I made representations that the itinerary for the July accompanied site visit should include traffic hotspots. The case manager replied on 8th July that "The Examining Authority note that potential traffic associated with the Proposed Development would not use the roads to the west of the A607 in Navenby and Harmston or the junctions at both ends of Green Man Road". I queried the accuracy of this statement and was advised to submit this query "at Deadline 3 (12 August 2025) through the Have your say submissions page. The Examining Authority will then take this into consideration".

HGV Routing

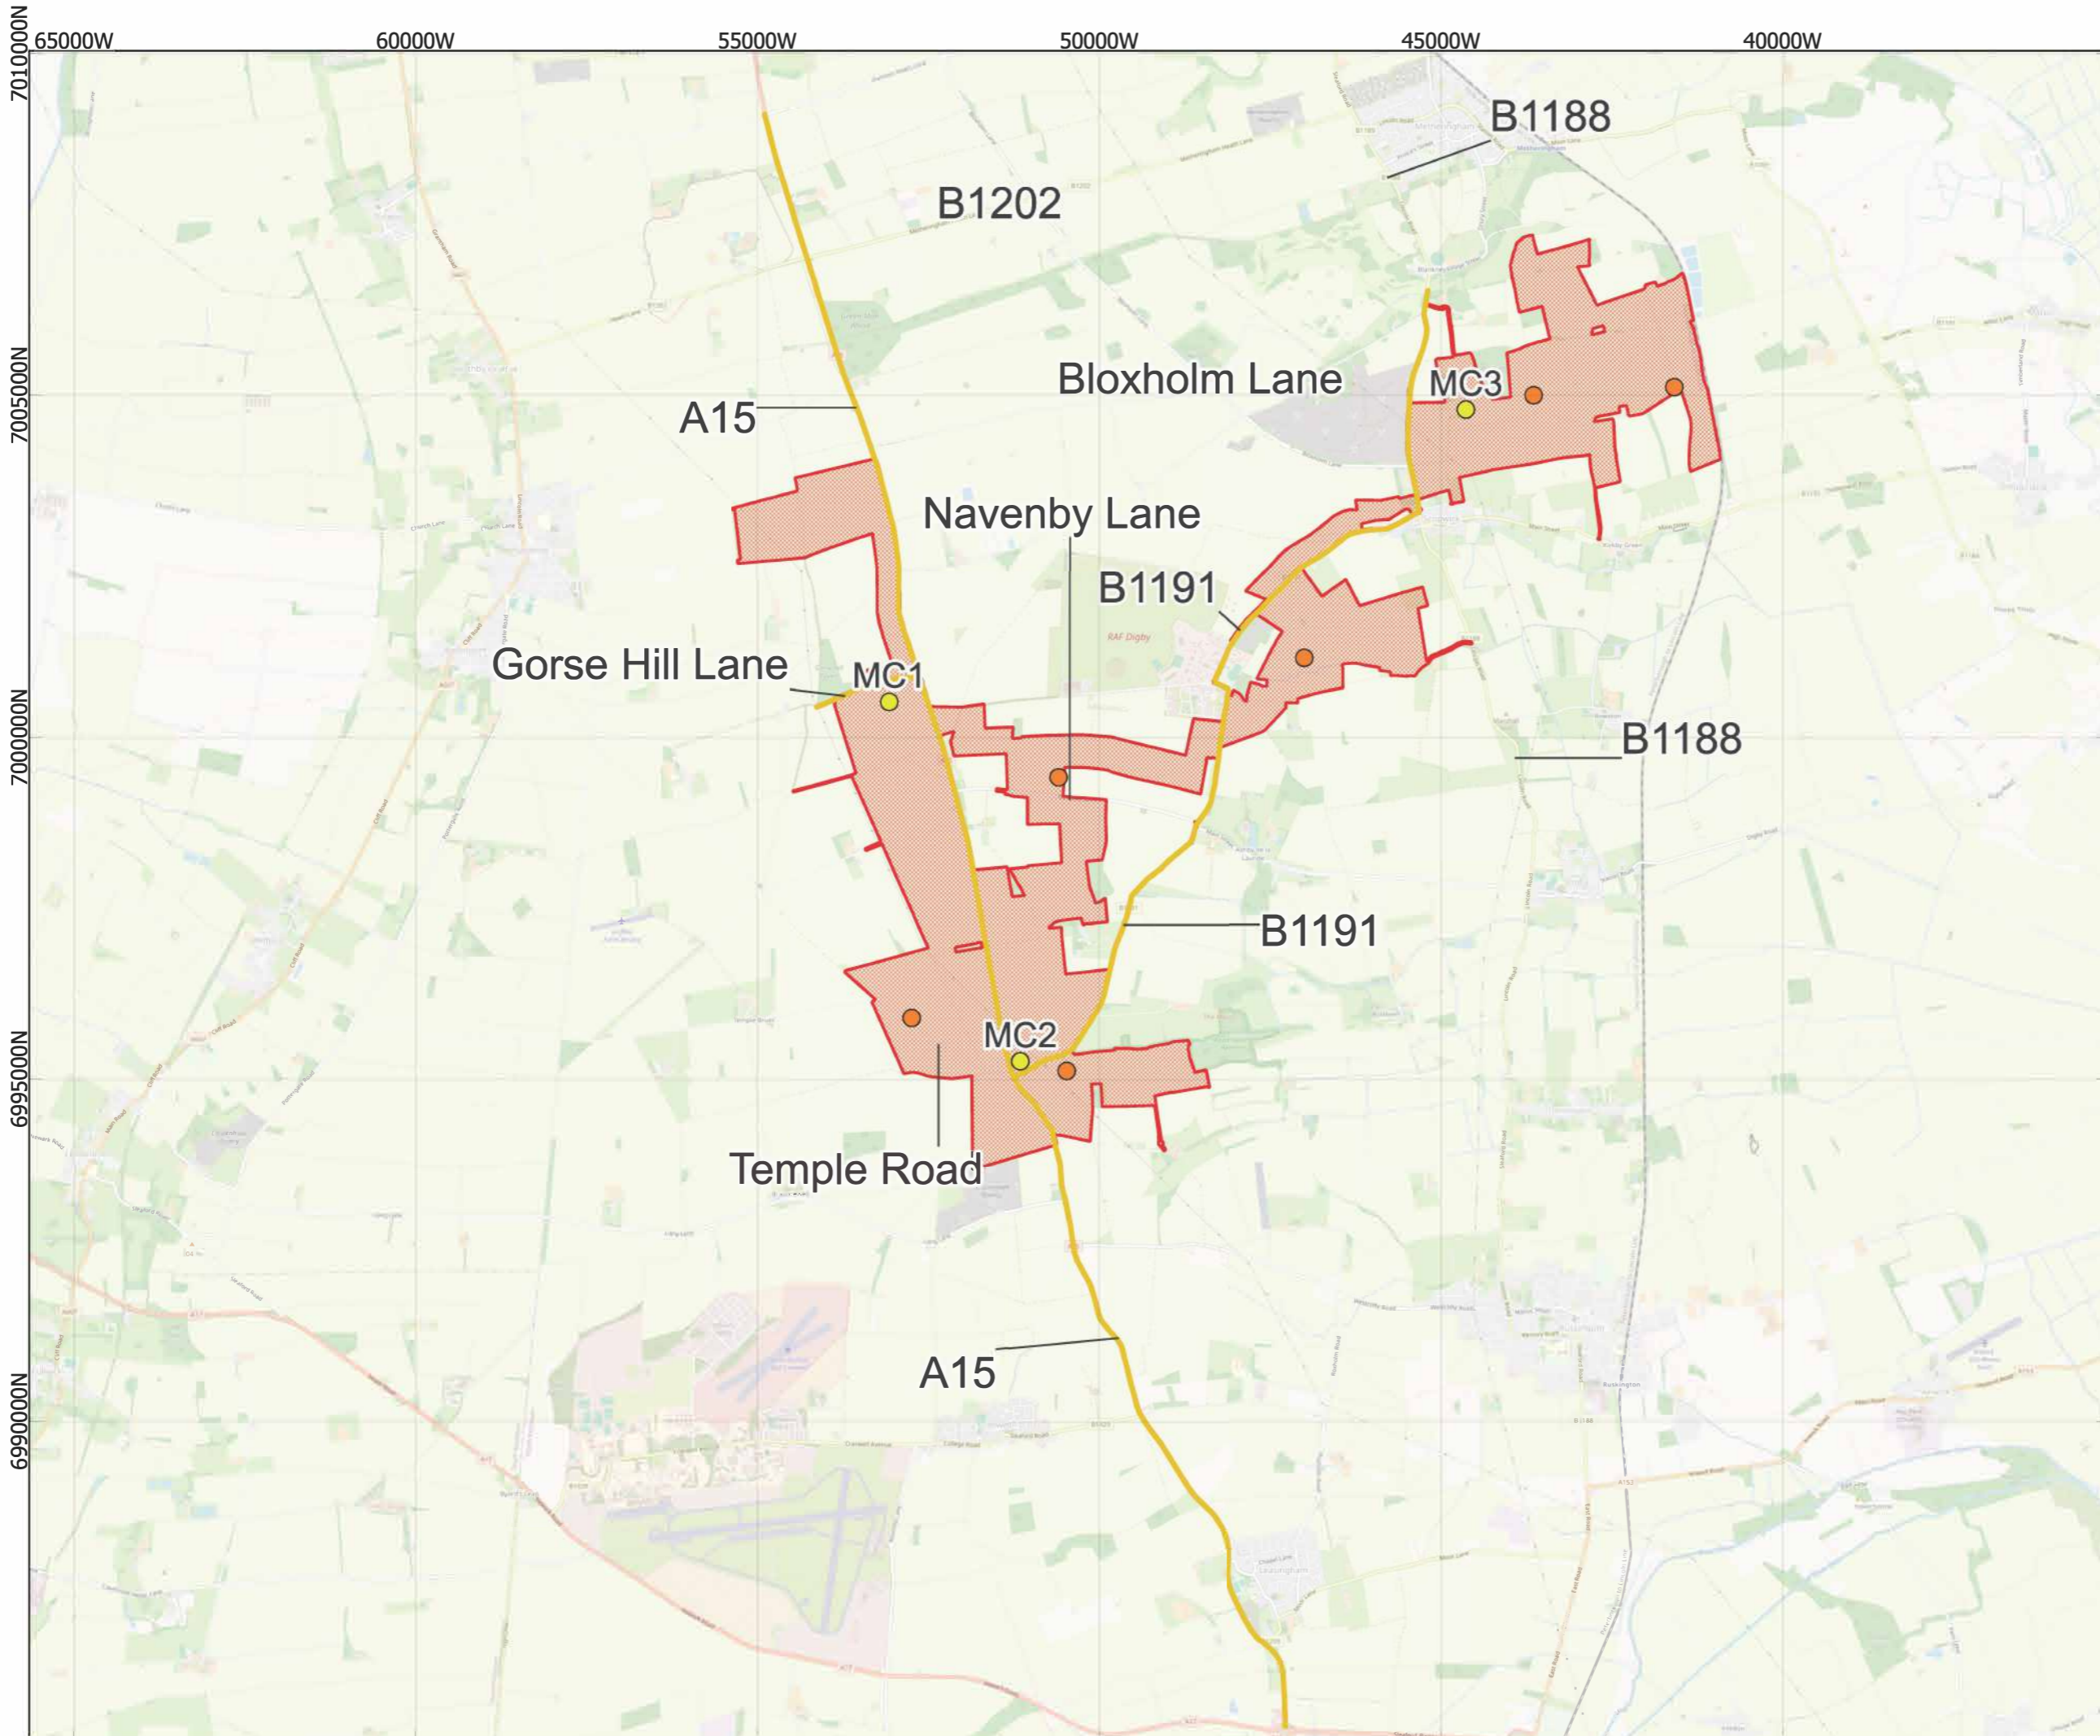
First, the case manager's email of 8th July stated that "traffic associated with the Proposed Development would not use the roads to the west of the A607 in Navenby and Harmston". Indeed fig 14.4 of the Environmental Statement (APP-070) shows neither HGV or LGV traffic routing to the A607. However, para 5.5.1 of REP1-062 says "All HGV construction traffic must adhere to the prescribed routeing strategy" but is silent on LGVs. As pointed out previously, the easiest route between the Springwell compounds and Newark, Hykeham (and more distant destinations via the A46) is to cross the A607 and travel through Navenby and Harmston. I therefore cannot see anything in the documents that ensures LGV construction traffic does not use the roads of concern. I therefore ask that the ExA consider the suitability of these roads for additional LGV traffic and, if there would be an adverse impact on Navenby and Harmston of LGVs, enquire whether and how the applicant proposes to enforce the prescribed routing strategy and prevent LGVs going through Navenby and Harmston.

My second point is that the 8th July email went on to say that "traffic associated with the Proposed Development would not use ... the junction at .. Green Man Road". The routing strategy shows HGVs and LGVs passing through the Green Man Road/A15 junction (albeit not travelling down Green Man Road). This is an accident hot spot and collisions here invariably involve at least one vehicle that is not using Green Man Road and should therefore be considered by the ExA. There are frequent injury accidents reported to the Police (using crashmap.co.uk, it can be seen there were 7 injury accidents at the junction during 2021-23, the last three years for which data is publicly available) as well as numerous other collisions (e.g. the road signs are regularly demolished by A15 traffic seeking to avoid read-end shunts with local traffic turning into Green Man Road). These collisions illustrate the unsuitability of the A15 at this point for development generating additional traffic. As always, I would add the cumulative traffic impact needs to be borne in mind (e.g. the proposed Navenby BESS construction traffic will all pass through the Green Man Road junction with the A15).
